3 Pleasant Ave Amendment App & Fast Track

From: John Shields <jshields1@maine.rr.com>
To: "Laurie Leader" <lr@portlandmaine.gov>
Cc: "Bob Gaudreau" <Bob@hardypond.com>
Date: Mon, 23 May 2016 12:31:01 -0400
Subject: 3 Pleasant Ave - Revision No 4

Drawing
NORTH & WEST ELEVATIONS

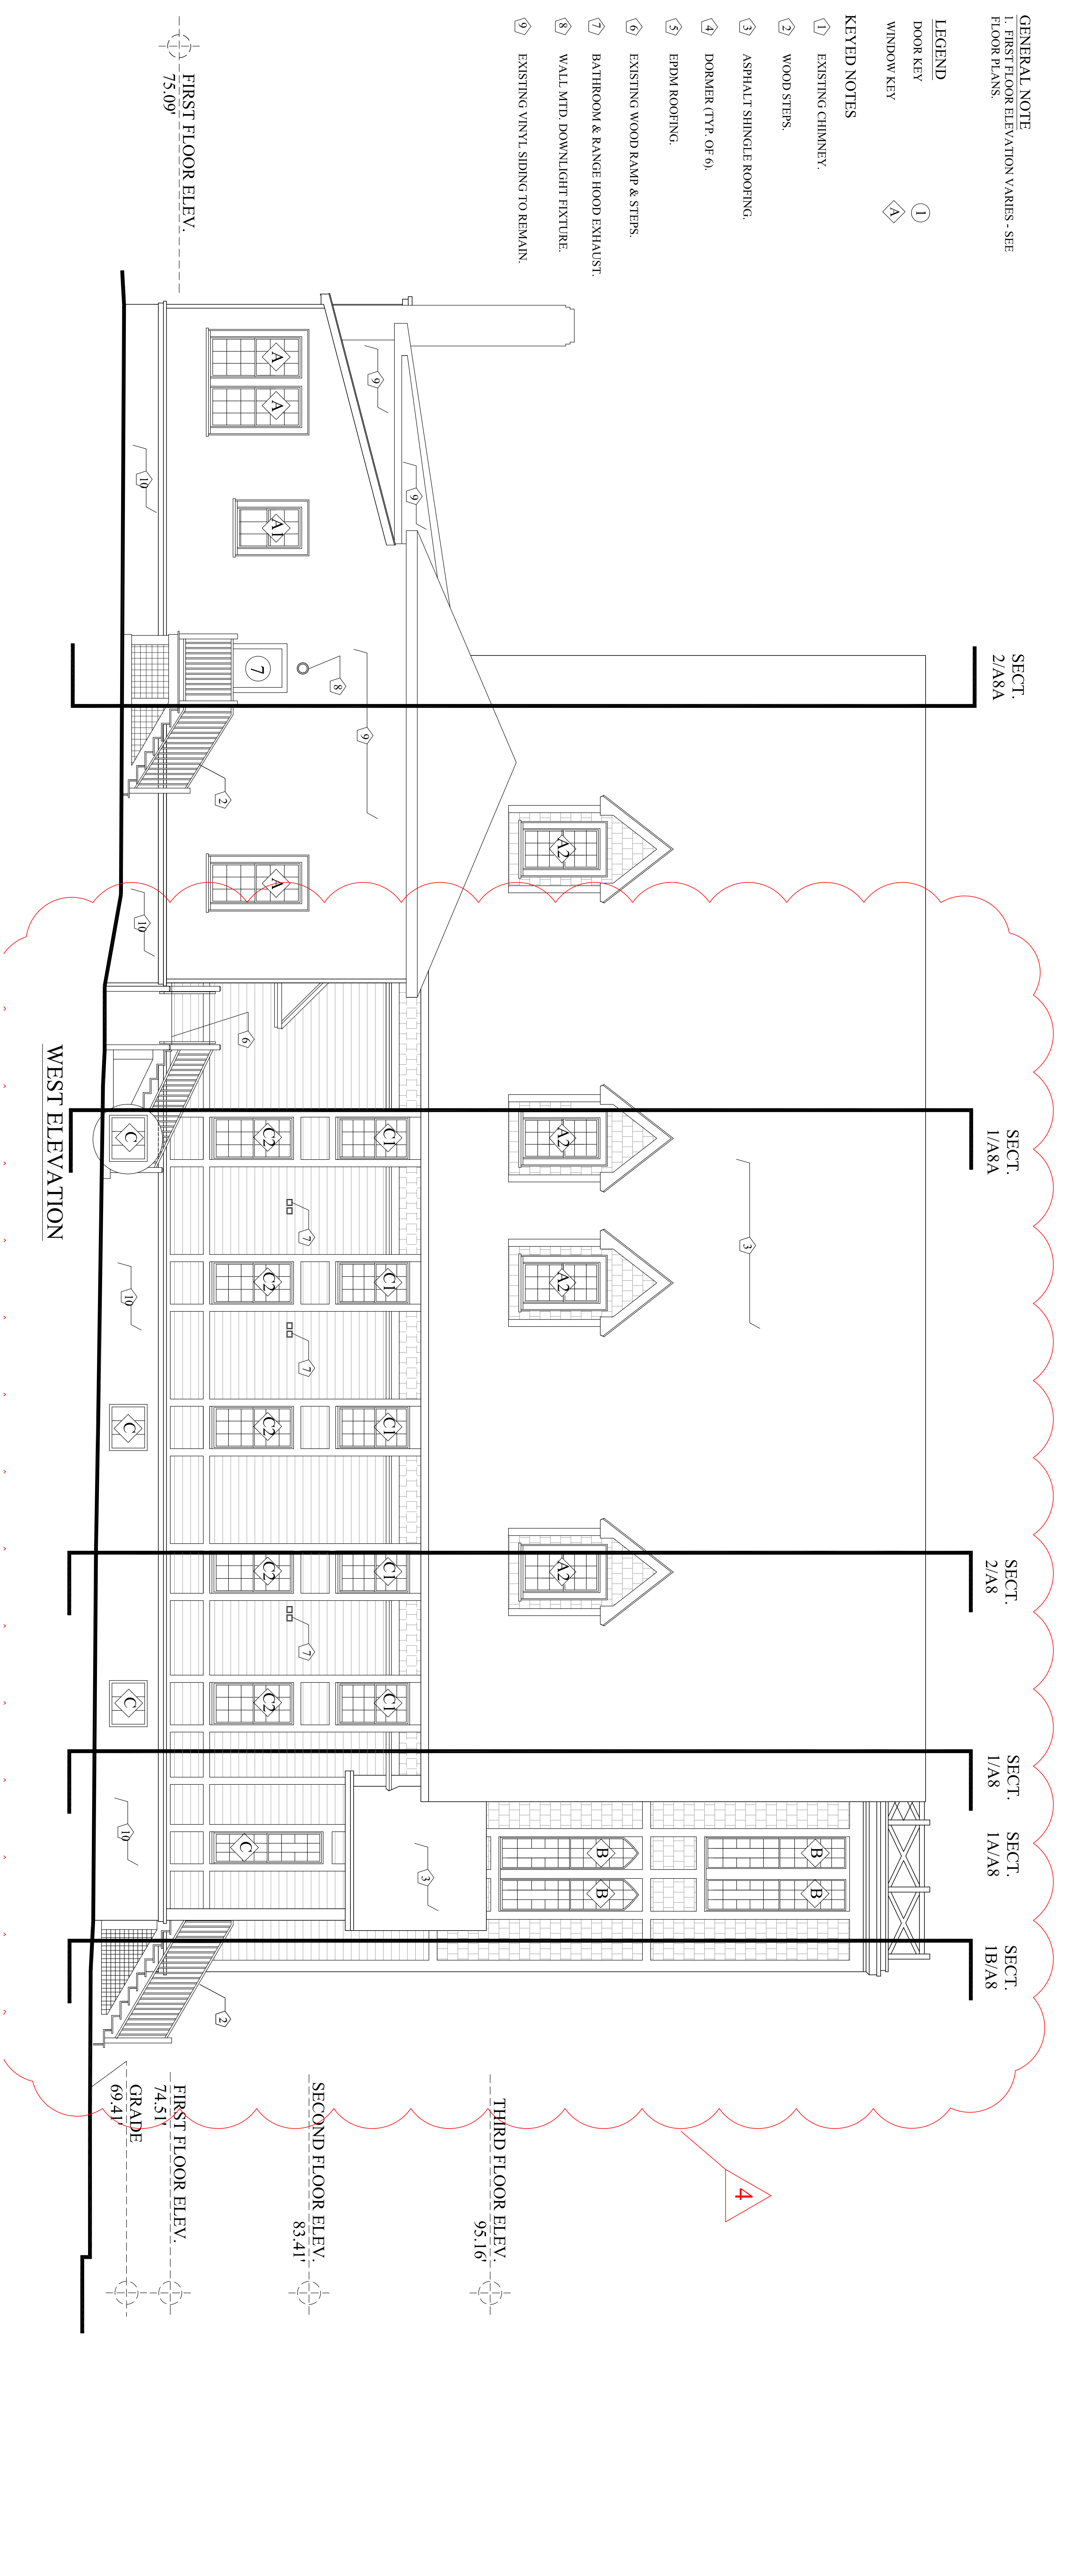
5. Drawing A-6 Exterior Elevations: Elevations changed in some areas to show removal of existing vinyl siding and painting of existing siding.
6. Drawing A-7 Exterior Elevations: Elevations changed in some areas to show removal of existing vinyl siding and painting of existing siding.
